**KIRKLEES METROPOLITAN COUNCIL
INVESTMENT & REGENERATION SERVICE**

**DELEGATED DECISION FOR APPLICATION FOR CERTIFICATE OF
LAWFUL DEVELOPMENT**

Reference no.: 2021/CL/91714/W

Description: Certificate of lawfulness for proposed erection of
extension and alterations to garage

Proposed Ground Floor Plan
Scale: 1:50

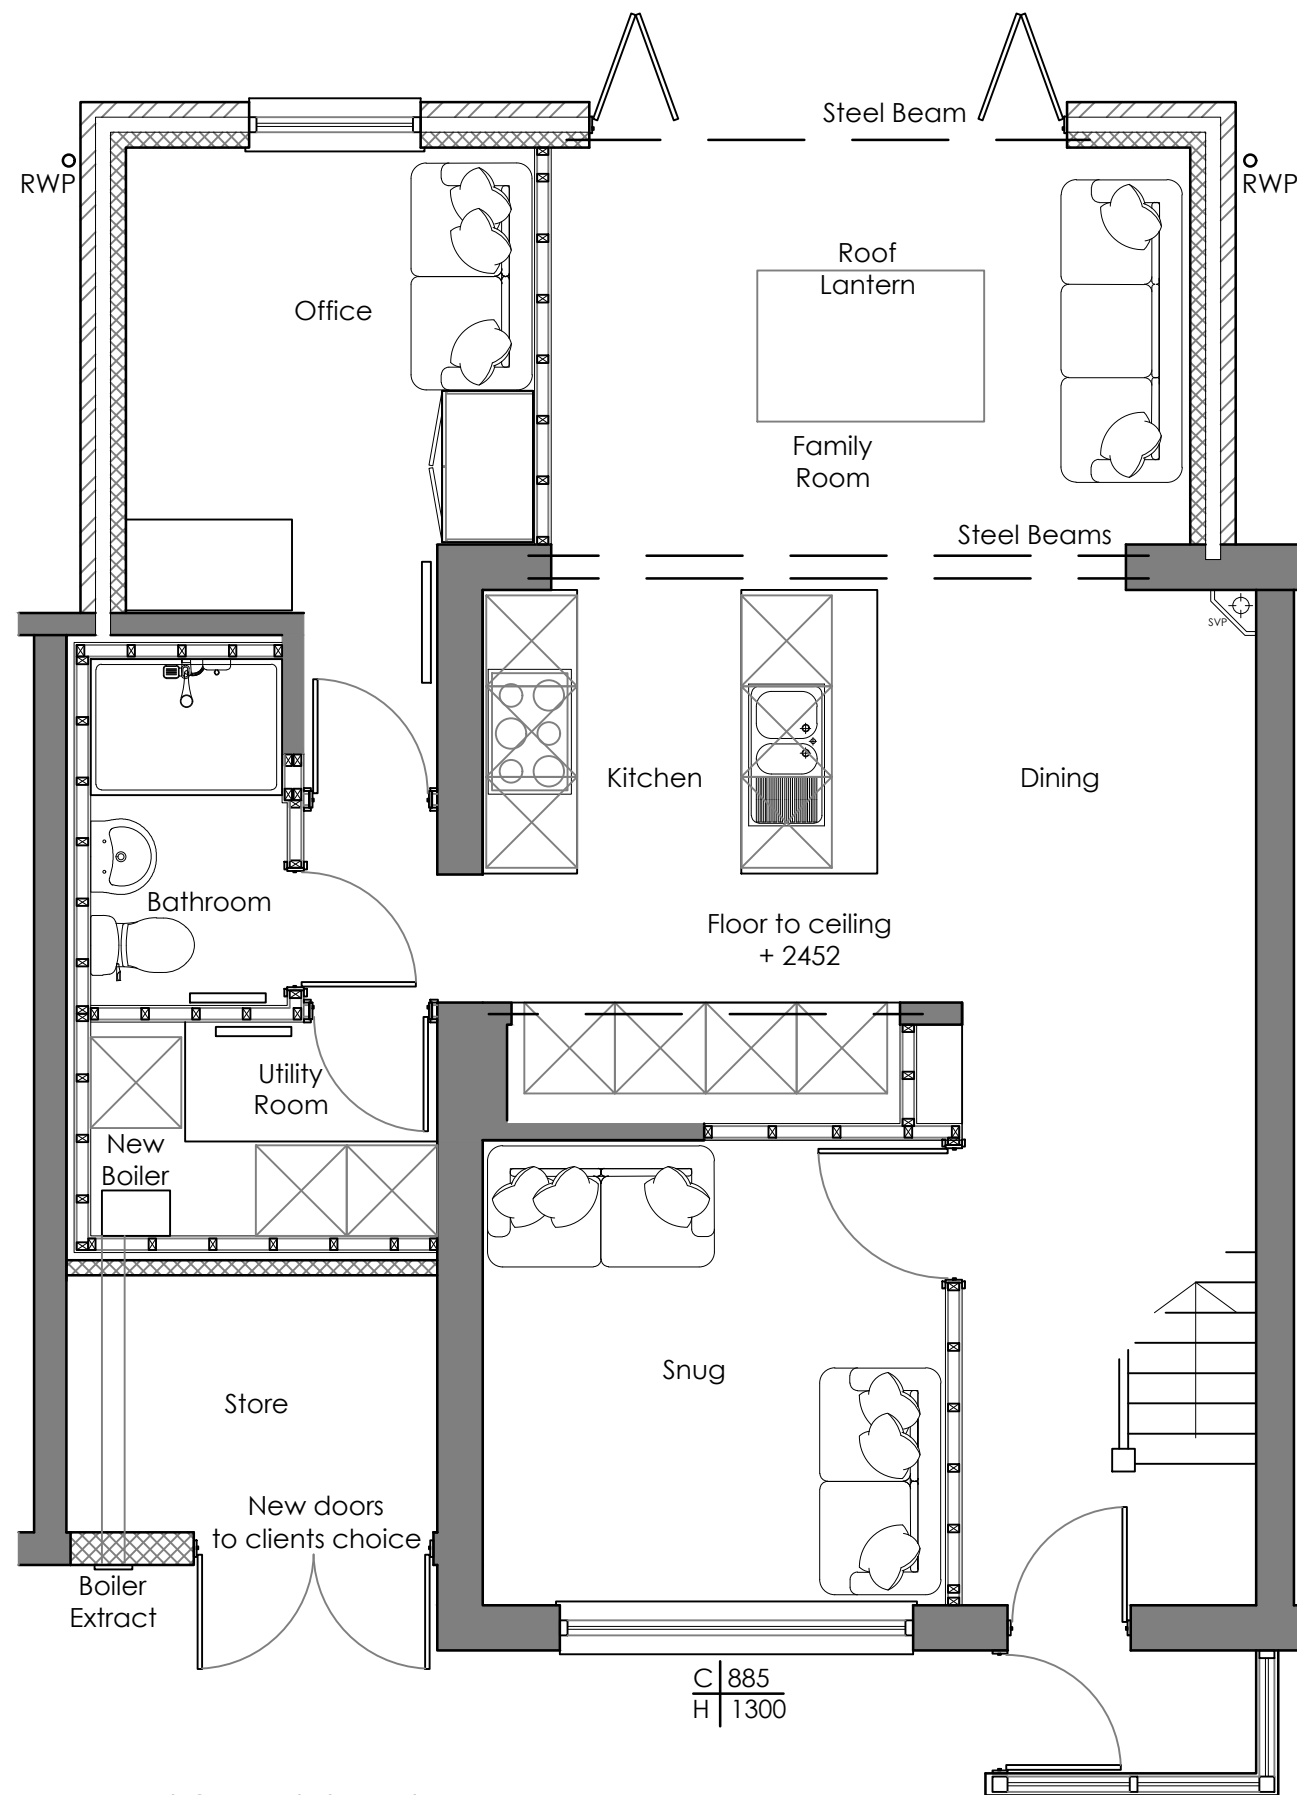
Comment: The rear extension would be single storey and extend out from the rear wall of the original dwellinghouse by 2.9m. It would also have a maximum height of 3.1m.

Comment: The enlarged part of the dwellinghouse would be within 2 metres of the boundary of the curtilage of the dwellinghouse, and the eaves would slightly exceed 3 metres in height measuring at 3.1m. Therefore the proposals would not meet the requirements of paragraph (i).

Comment: The proposed extension would not exceed 4 metres in height, would not have more than a single storey, but would extend beyond a side elevation (rear of garage) and have a width greater than half the width of the original dwellinghouse (8.3m). It can be seen from the Council's historical mapping sheets that the original dwellinghouse included the attached garage which did not extend the full depth of the building thus leaving a small section of walling to the rear which would be regarded as a side elevation. The proposals would therefore not meet the requirements of paragraph (j).

Comment: The property is on article 2(3) land and whilst it wouldn't consist of or include any cladding to the exterior of the dwelling, or be more than single storey in height, it would enlarge the dwellinghouse beyond a wall forming a side elevation of the original dwellinghouse (to the rear of the garage). The proposals would therefore not meet the requirements of paragraph A.2.
